WEST SUSSEX COUNTY COUNCIL CONSULTATION

TO:	Arun District Council FAO: Anita Gardner
FROM:	WSCC - Highways Authority
DATE:	3 August 2021
LOCATION:	Wicks Farm Ford Lane Ford BN18 0DF
SUBJECT:	F/7/21/PL Building a new 1.28 Ha high-tech glasshouse, reservoir and parking area adjacent to the existing 6 Ha glasshouse, reservoir and nursery area. This site is in CIL Zone 3 (Zero Rated) as other development.
DATE OF SITE VISIT:	n/a
RECOMMENDATION:	Advice
S106 CONTRIBUTION TOTAL:	n/a

Drawing Title
Proposed Site Extension

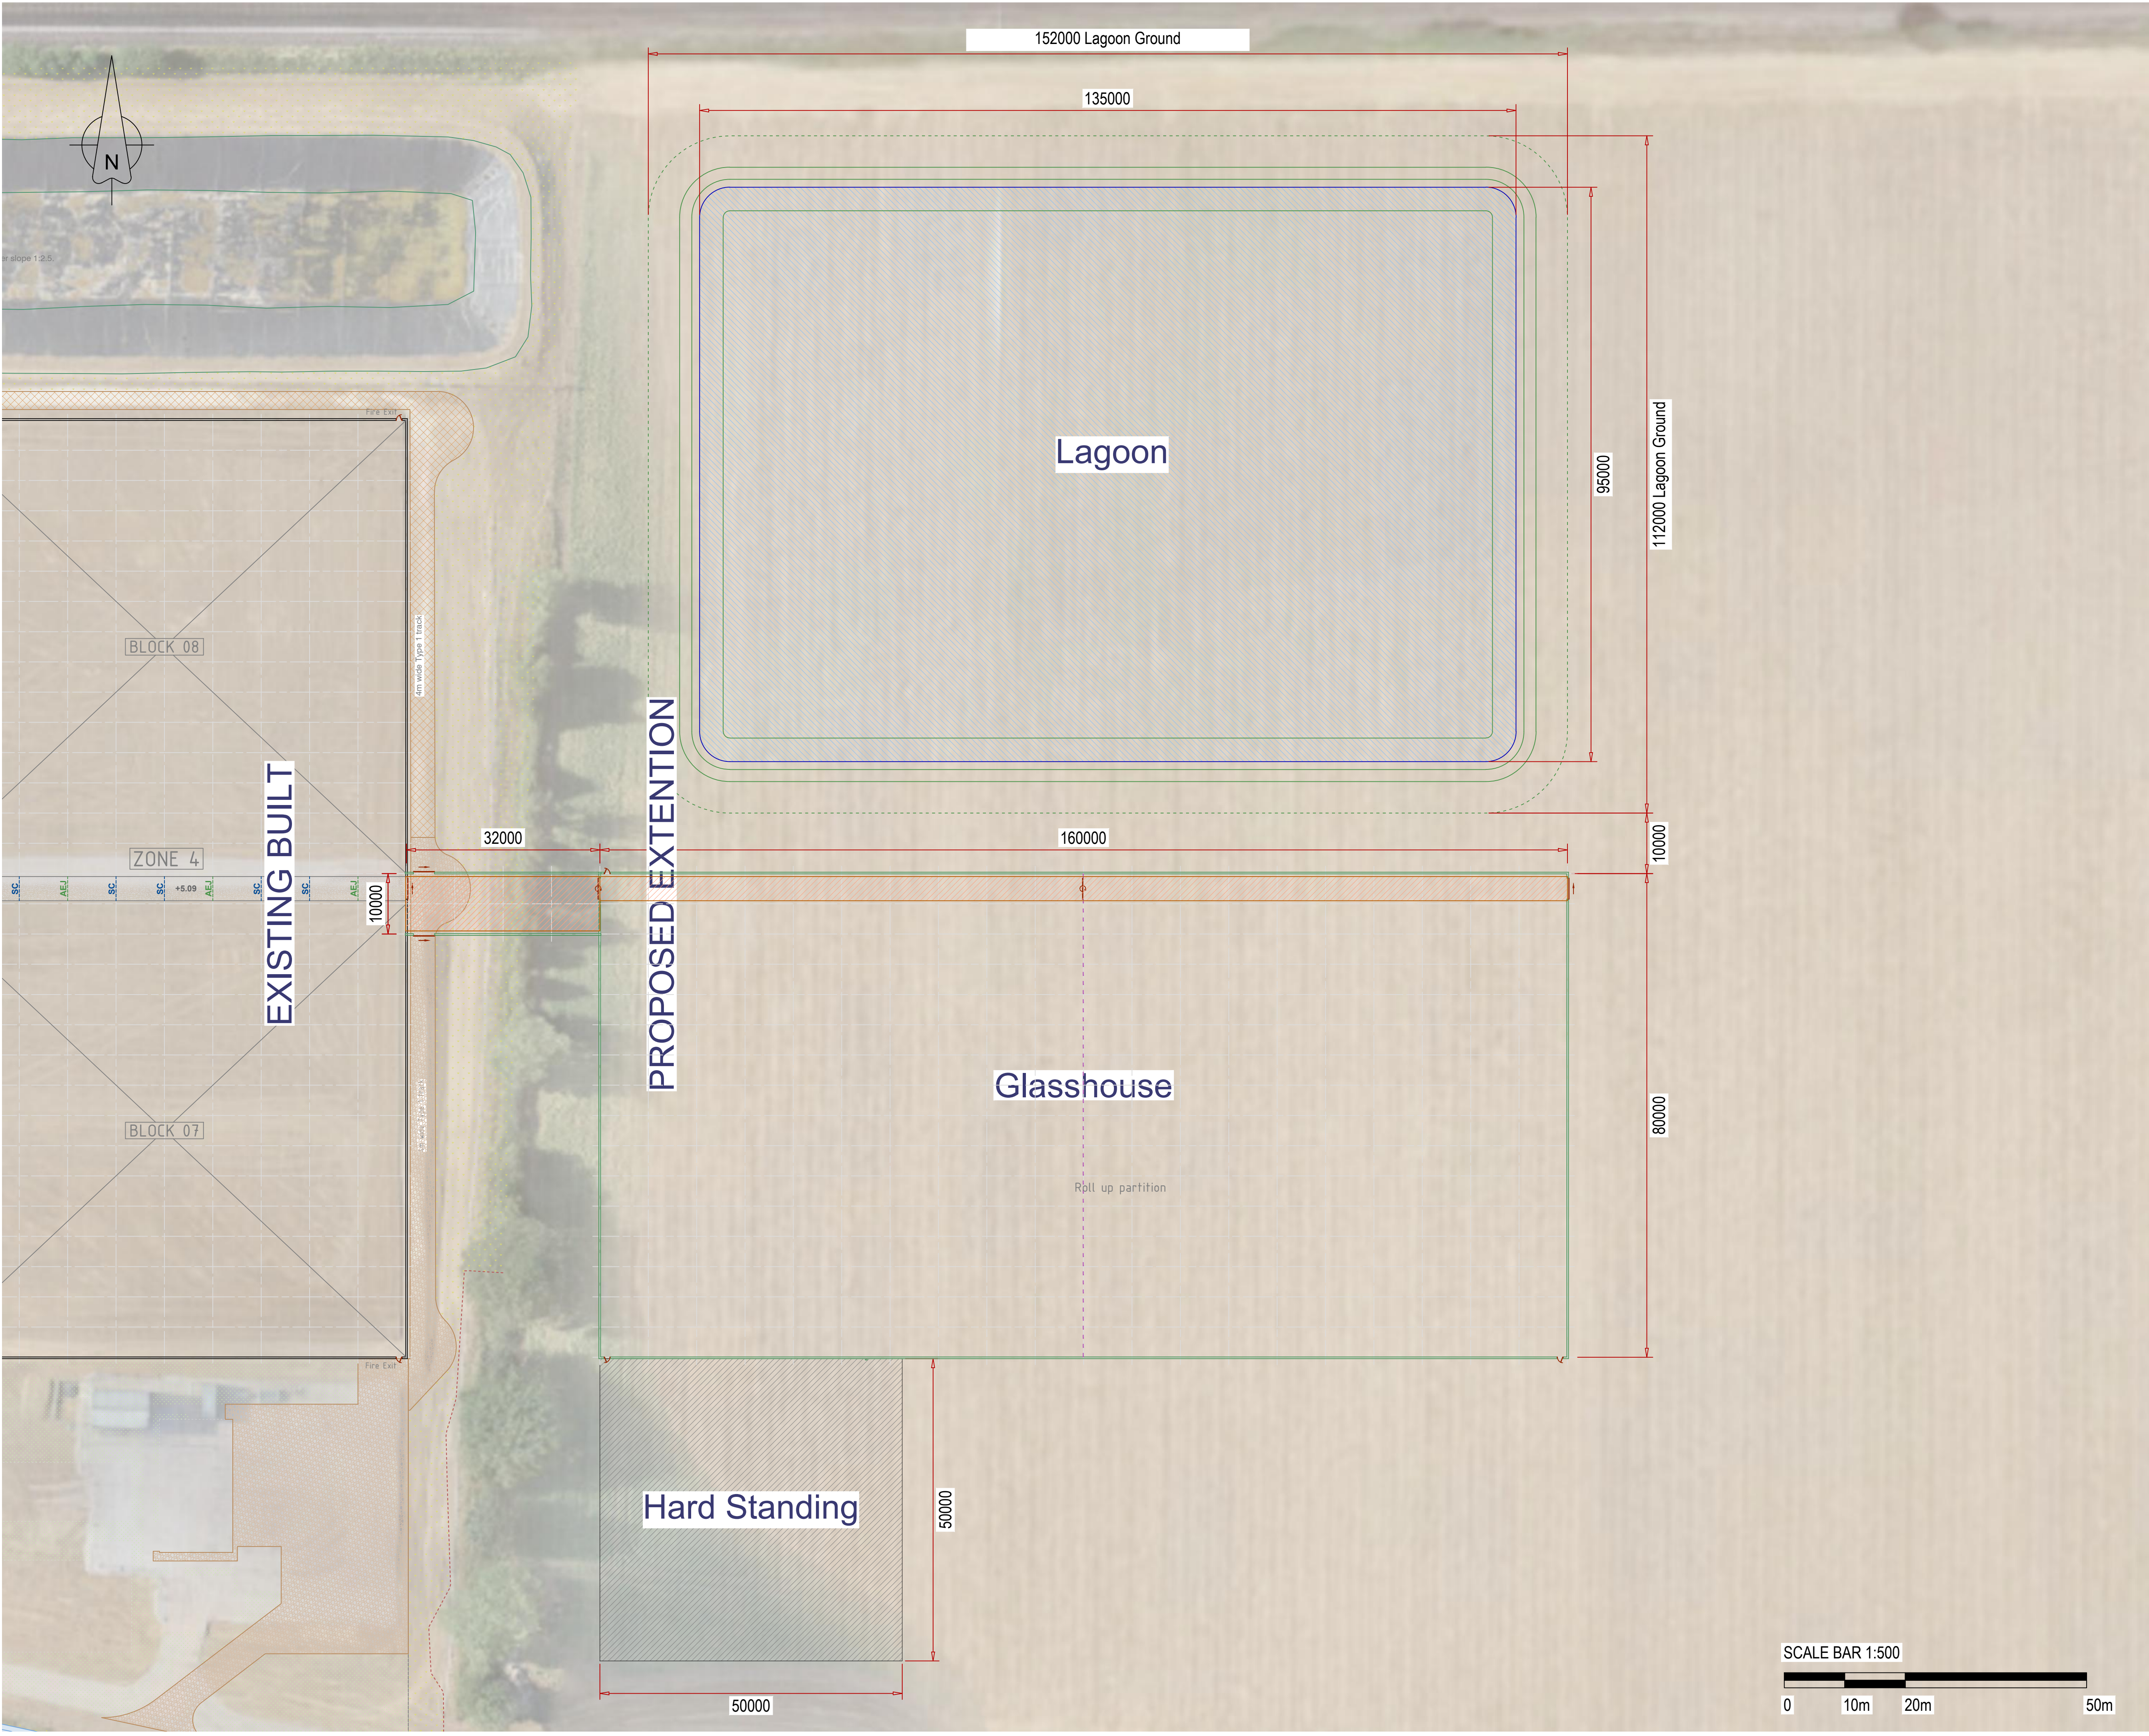
The applicant has confirmed that the access approved under F/23/19/PL will be utilised for the proposal. The LPA should be aware that the Site Location Plan numbered 6648-CHOK-GH-GF-DR-P-0010-002 shows the incorrect access point within the red-edge of the site. The Proposed Site Layout Plan numbered 03 shows the correct access red-edged. The LPA should consider whether the red-edge plan(s) would require amending.

The Transport Statement indicates that no additional parking will be required, as all new staff trips will be by minibus although the LHA note that a proposed parking area is included within this application. The plan does not demonstrate how the parking area will be accessed within the site, as it appears to be isolated. The applicant has confirmed that this parking area will be utilised by HGVs and staff minibuses, and will be accessed via internal access roads. The plans does not demonstrate provision of internal access roads, however the LHA would not raise any highway safety concerns to this arrangement as it would be considered an amenity issue.
